City of Albuquerque

April 23, 2001

**Re: Grading and Drainage Plan for Corona del Sol Townhomes,
(G11/D58), Engineer stamp dated 04/20/01.**

REV.	DATE	DESCRIPTION
PROJECT TITLE		
Corona Del Sol Townhomes		
Sequoia and Arcata Ct.		
Albuquerque, NM		
SHEET TITLE		
Drainage Plan		
CAMI		
CONSTRUCTION ANALYSIS & MANAGEMENT, INC.		
DRAWN BY: BEH		
CHK'D BY: Raymond Henley, P.E.		
DATE: 04/20/2001		
D1

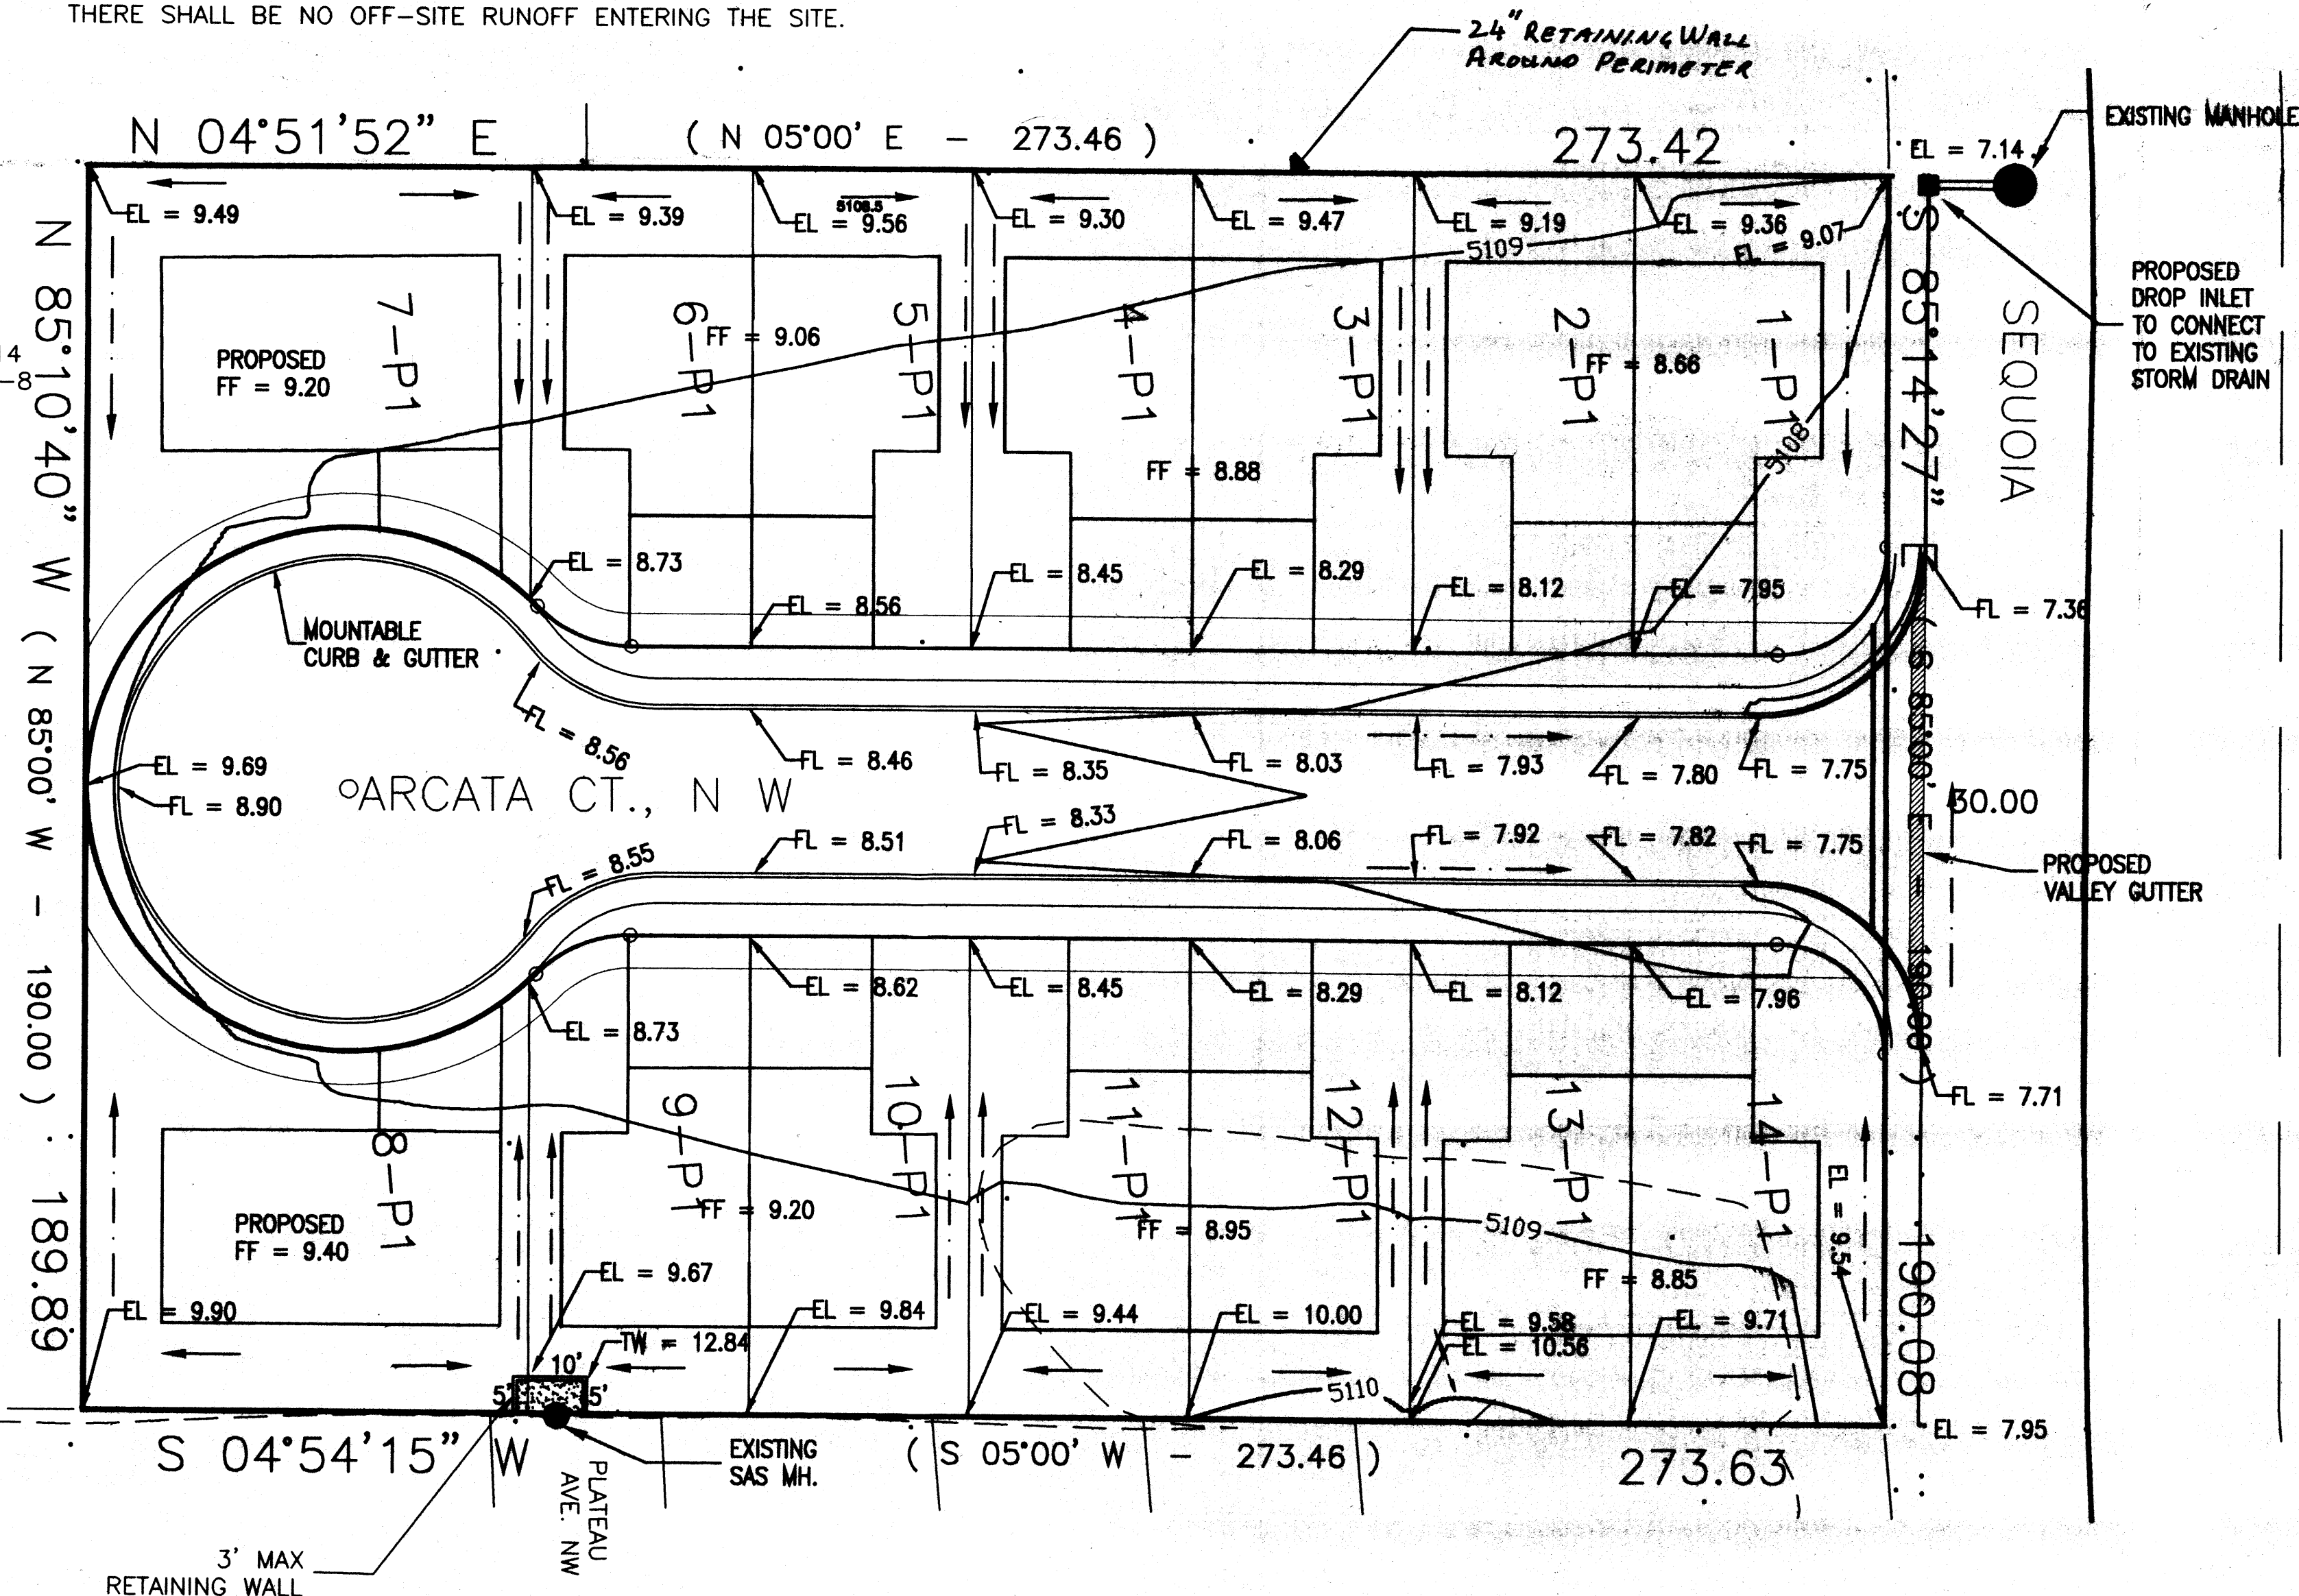
1. Show existing ground spot elevations for adjacent properties surrounding the proposed subdivision.
